Application No: Y/5/26/PL

Site Address: 2 Downview Road Yapton BN18 0HS

Description of works: Erection of terrace of 4 No town houses with gardens and parking spaces. This application is in CIL Zone 2 and is CIL Liable as new dwellings.

Thank you for your internet representation made on 16th March 2026 which has been recorded as an objection with the comments as follows:

2 Downview Road, Yapton : Proposed 4-unit 3-storey Terrace of 3-bedroom Dwellinghouses : PROPOSED SITE LAYOUT

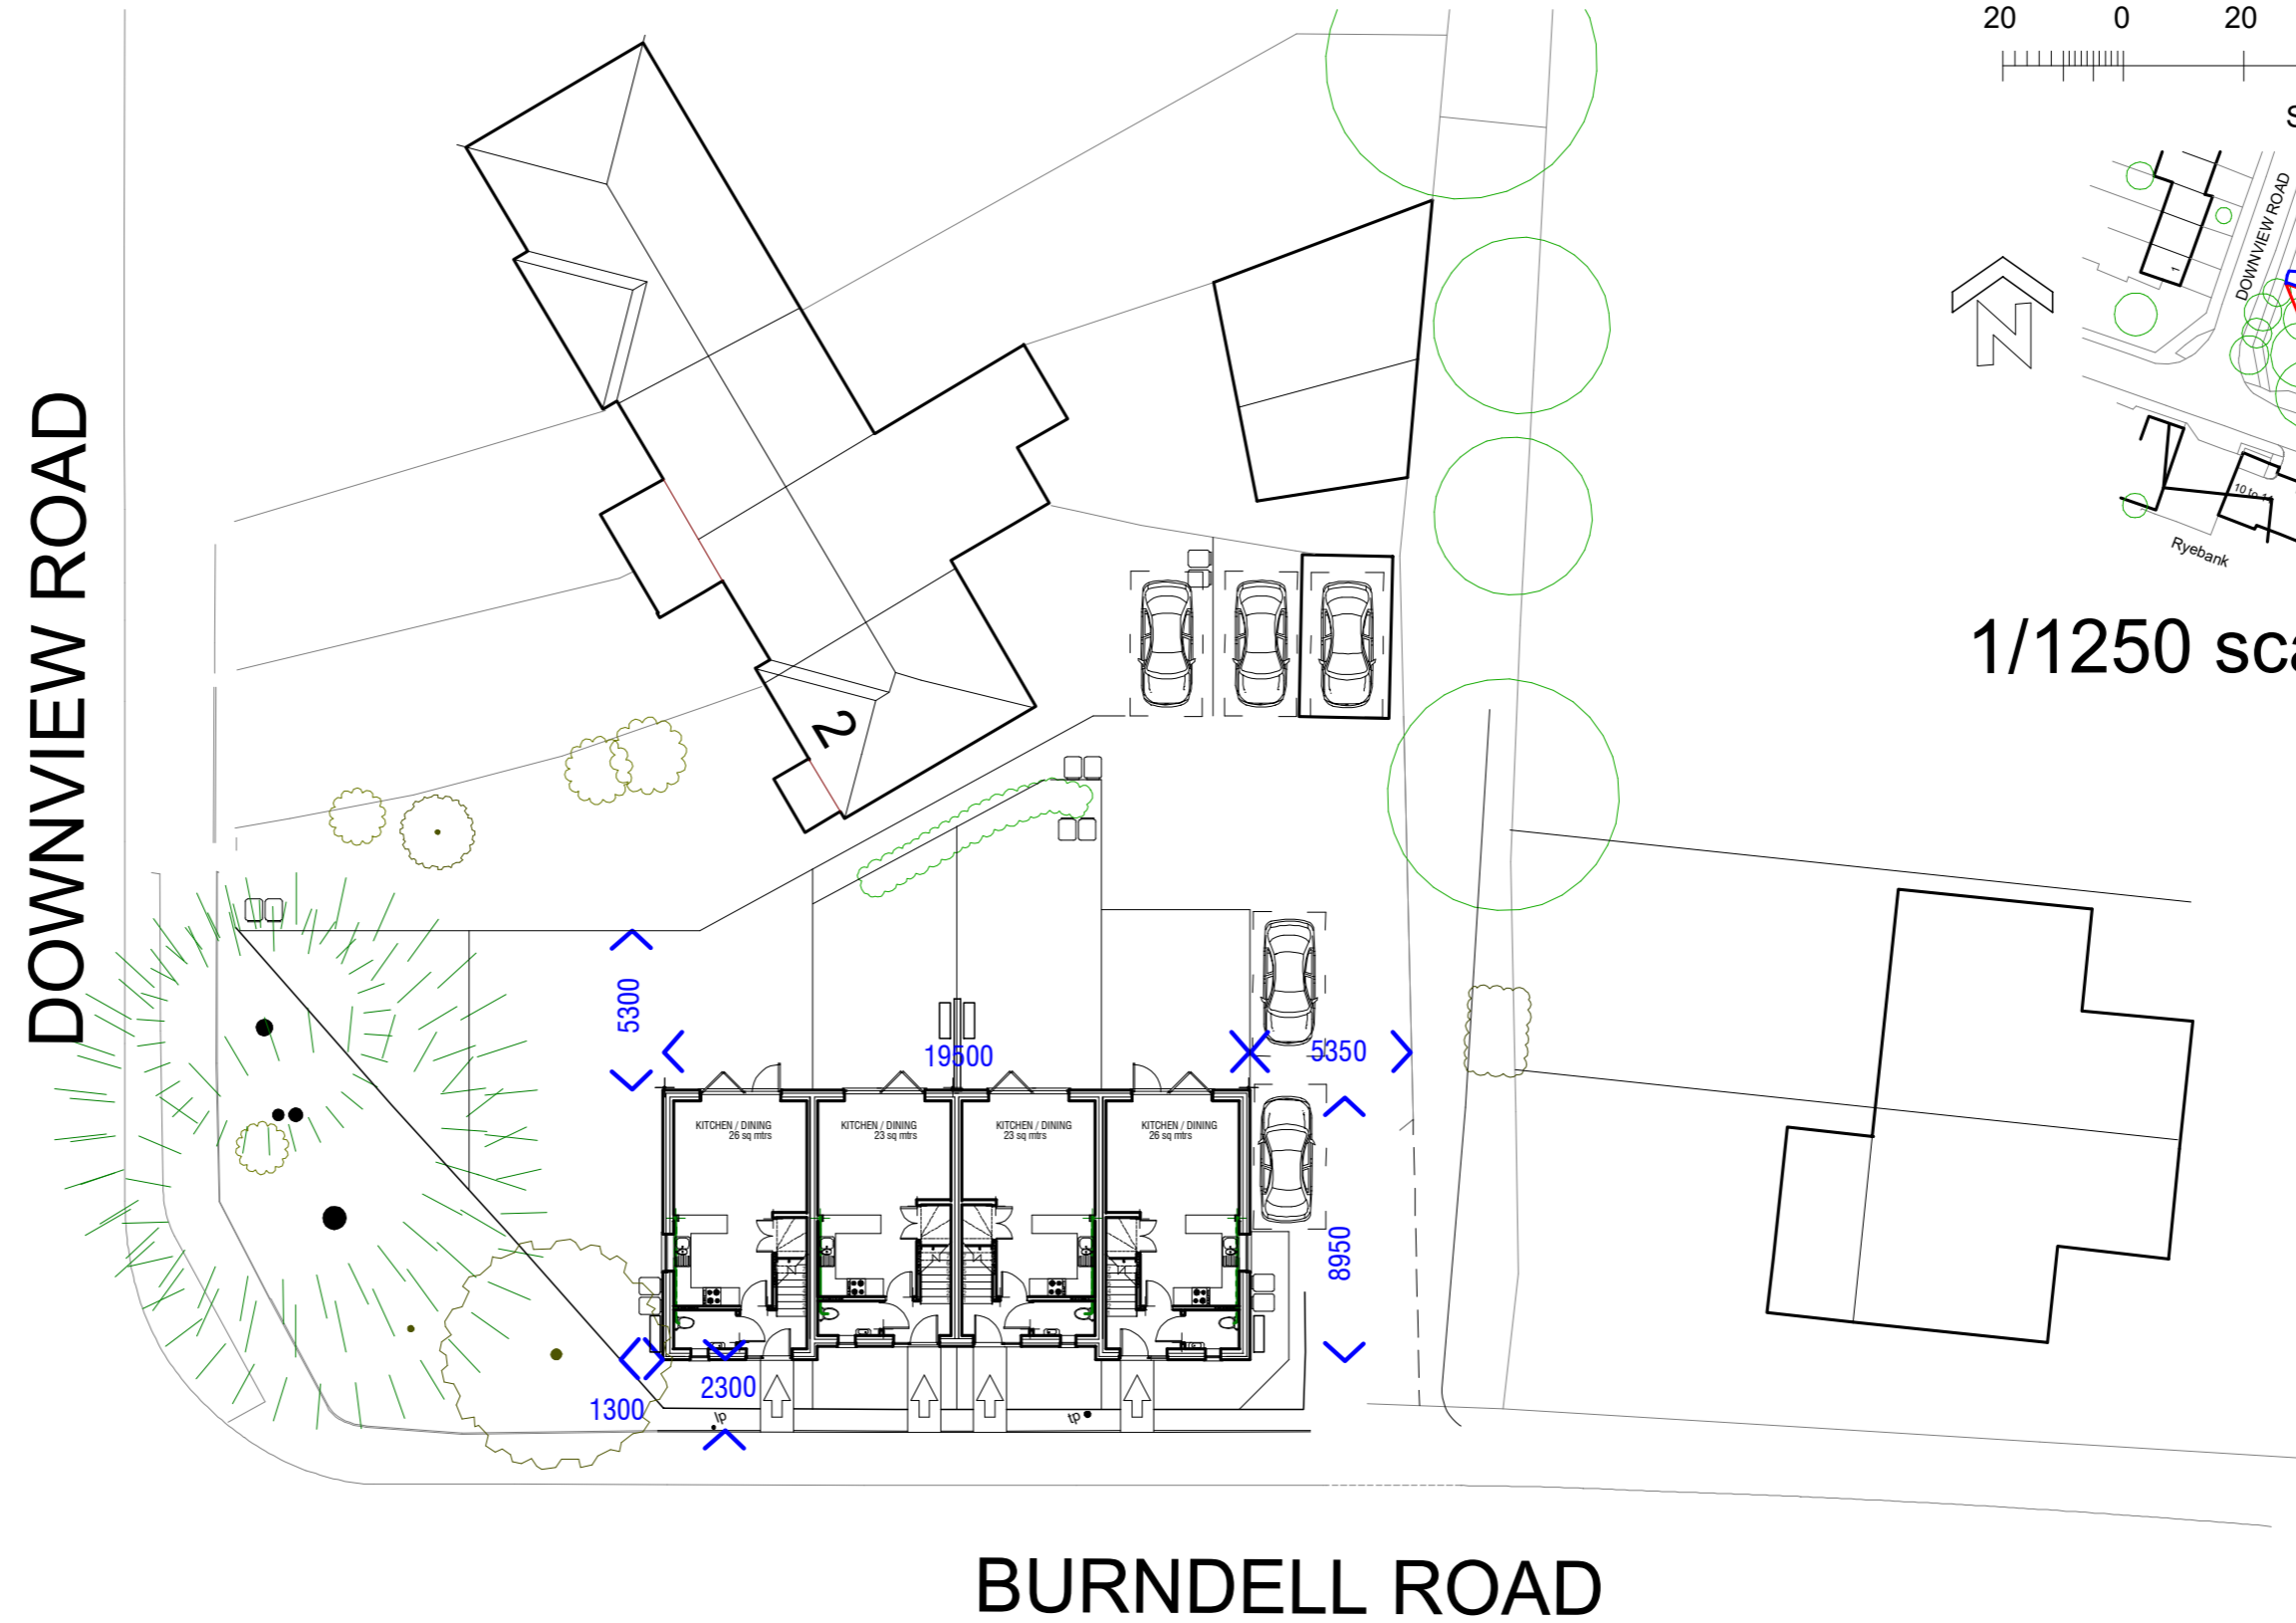
The owner of this property has taken the grass verge which bordered Burndell Road into his garden boundary to allow for this development. Parking on the Downview Estate is extremely congested as vehicles belonging to the Cottages and Flats on Burndell Road together with vehicles from Navigation Drive use Downview as a car park. We have an Old Peoples home on the Downview Estate and delivery lorries and the Emergency services have great difficulties negotiating the corner into Downview Way due to parked vans and cars. The new very high fence that has now been erected impedes the line of vision for vehicles exiting Downview Road and turning right onto the busy Burndell Road.
